OUR REF S6530.18/CBW/CWI
21 July 2026

Norwich to Tilbury Project (the “Project”)

Application Ref: EN020027

**ScottishPower Renewables (UK) Limited, East Anglia THREE Limited and East Anglia ONE Limited’s
Deadline 7 Submission**

THE NATIONAL GRID (NORWICH TO TILBURY) ORDER  
 LAND PLANS  
 REGULATION 5(2)(i)-(iii)  
 SECTION B (SHEET 20 OF 22,  
 MID SUFFOLK DISTRICT COUNCIL AND BABERGH DISTRICT COUNCIL)

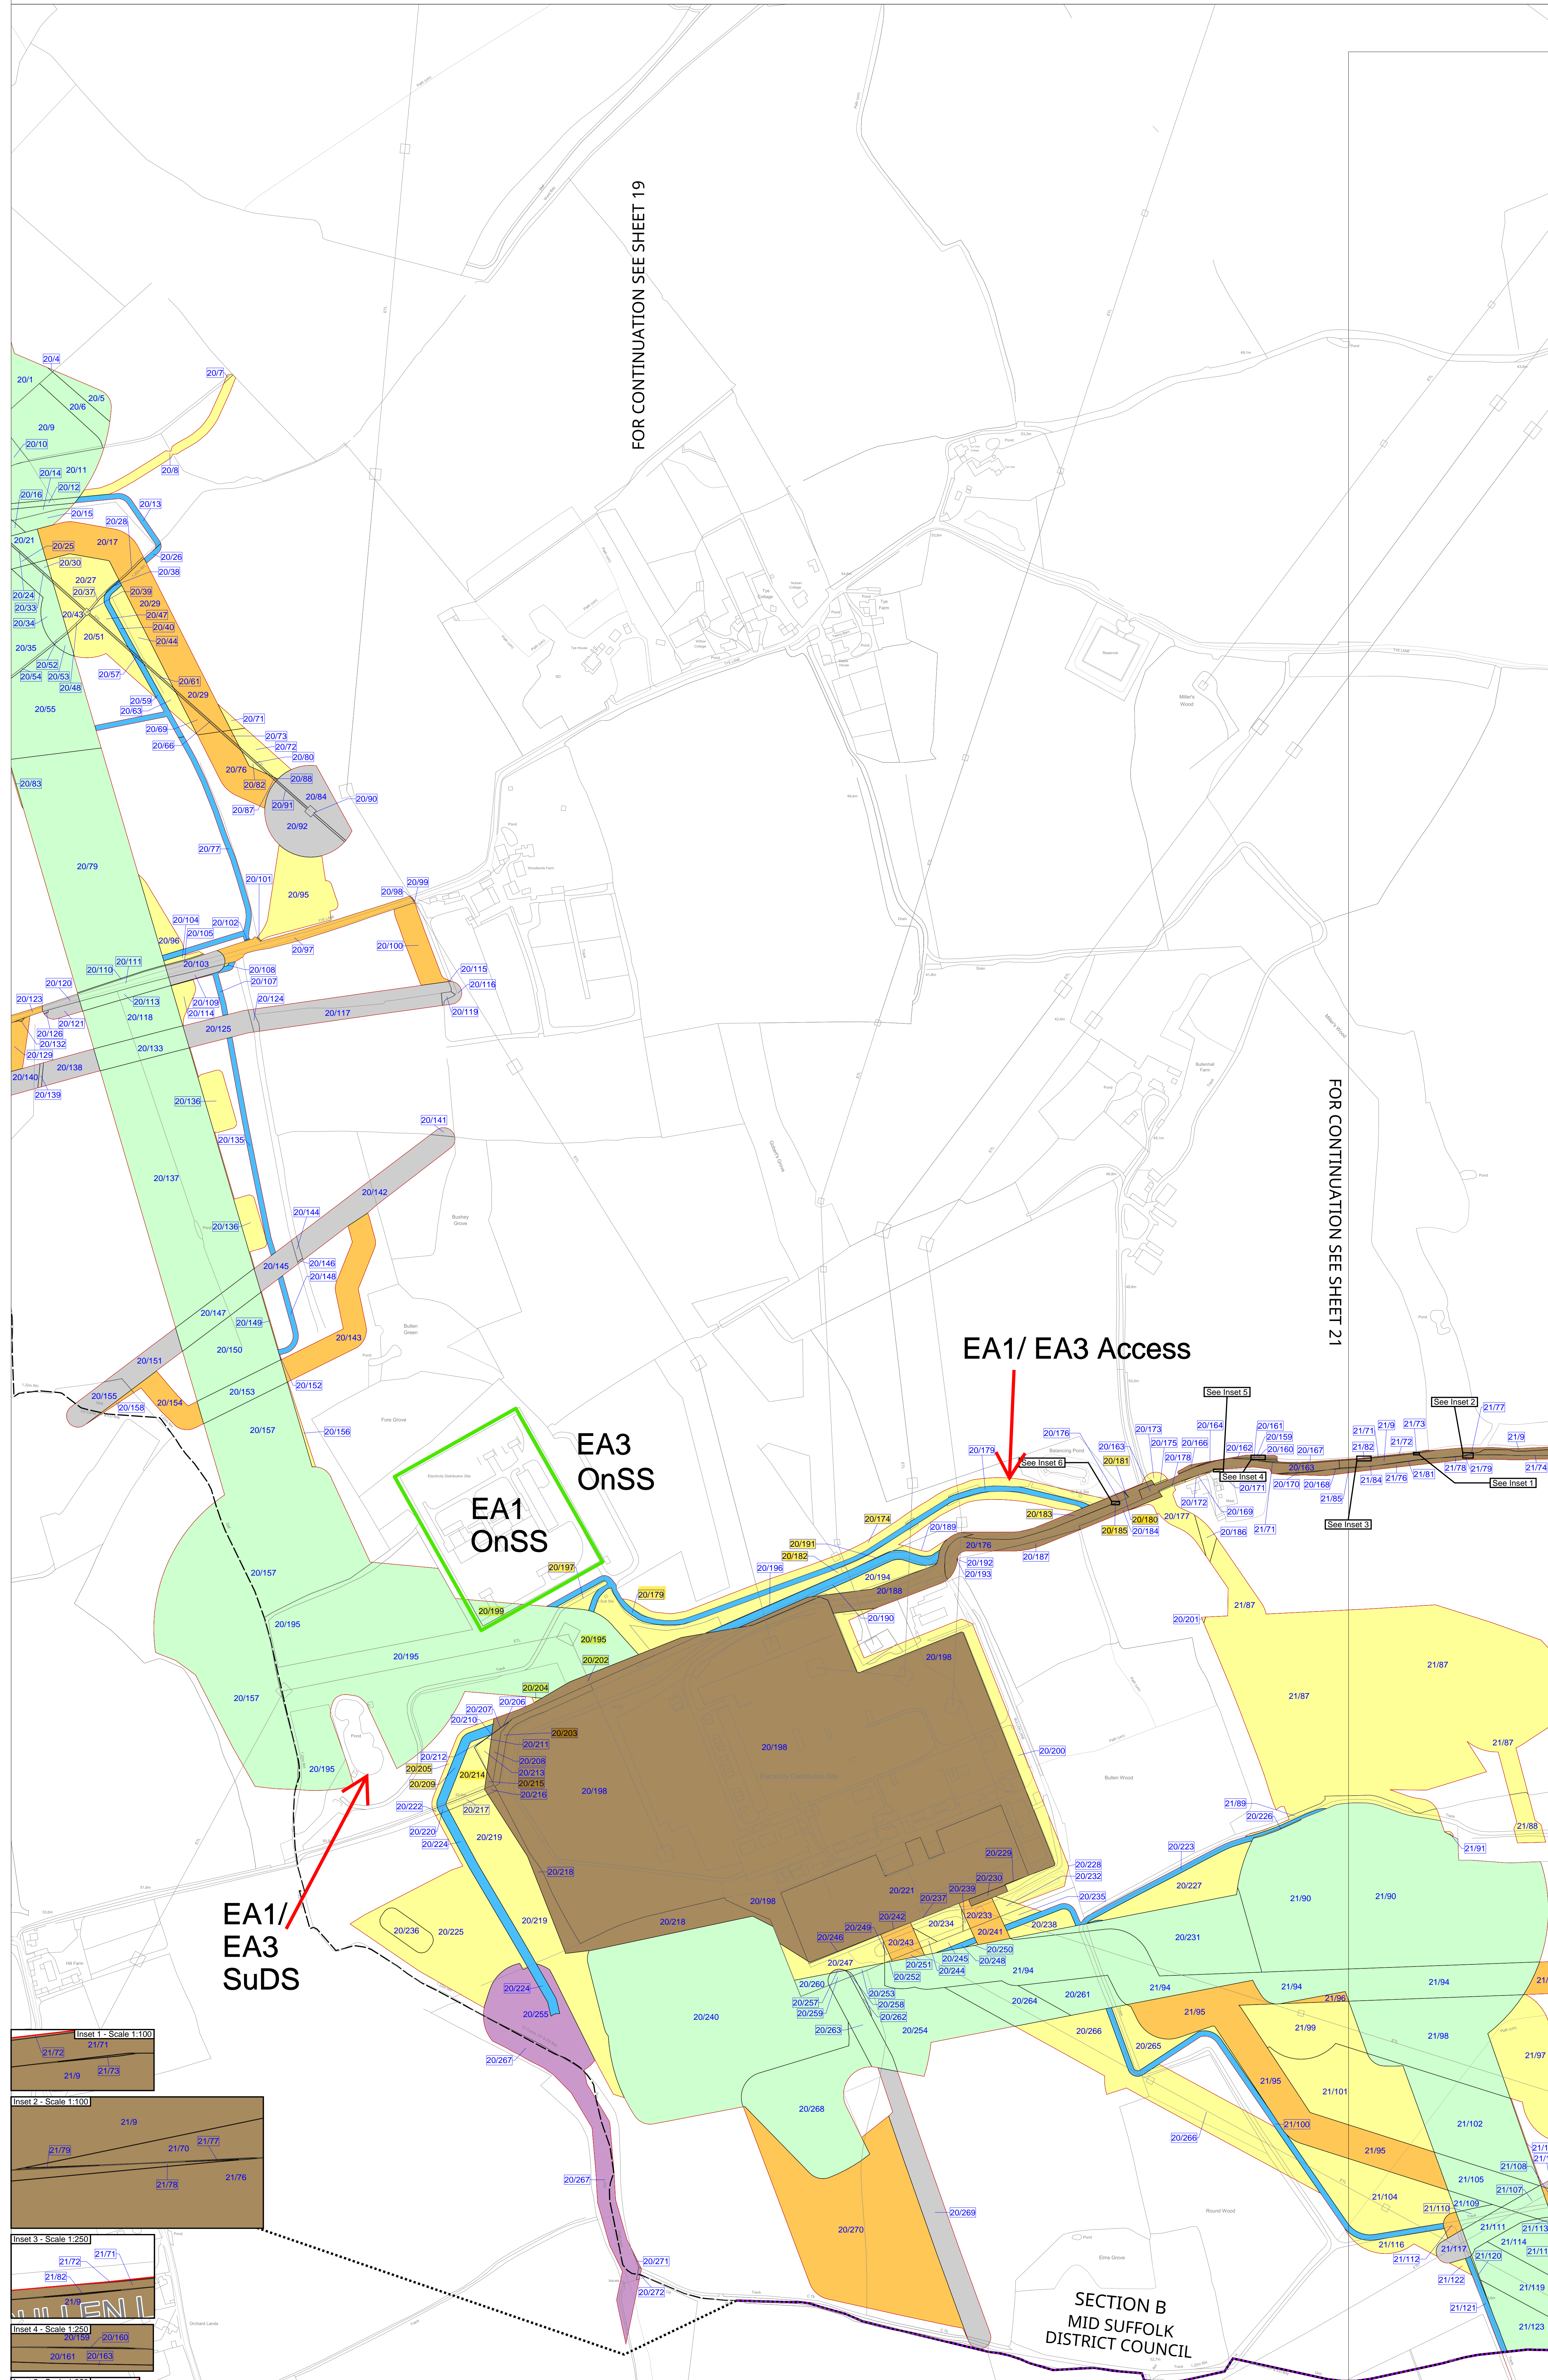
- 3.1 The SPR Parties are grateful that the Applicant has reclassified Plot B-20/199 as Class 8 land. However, in undertaking this amendment, it has transpired that Plot B-20/199 does not include the fully fenced substation area.
- 3.2 The SPR parties note that a section of the fenced area of the EA1 substation is not included within the Class 8 boundary of Plot B-20/199. As a result, the section in question appears to form part of Plot B-20/195, which is Class 2 land.
- 3.3 The SPR Parties have made representations to the Applicant that this area also requires to be reclassified as Class 8 land. Until these matters are resolved, the SPR Parties' concerns about the Applicant's Compulsory Acquisition and Temporary Possession powers over land owned by SPR and forming part of the operational EA1 substation will remain.

- 4.2 In respect of the Land Plans, we note that the Applicant's remarks in the Applicant's Comments document that Plot B-20/180 is designated as Class 7 (yellow) land, and not Class 1 (brown) land. We note the Land Plans are not reflective of this. Whilst the SPR Parties welcome the Applicant's confirmation that they are only seeking Class 7 rights over Plot B-20/180, this is unclear on the Land Plan. To that end, we request that an inset is added to this sheet of the plan to ensure that this is clear on the Land Plans which would be certified were the application to be granted.

- 4.4 Finally, we note that in respect of the Applicant's Statutory Undertaker Tracker, various amendments have been made in respect of the SPR Parties interests. To confirm, as the freehold owner of plots B-20/181, 183, 185, 202 and 215, SPR's interests at row 24 should be listed in the first CA column, rather than the second CA column.
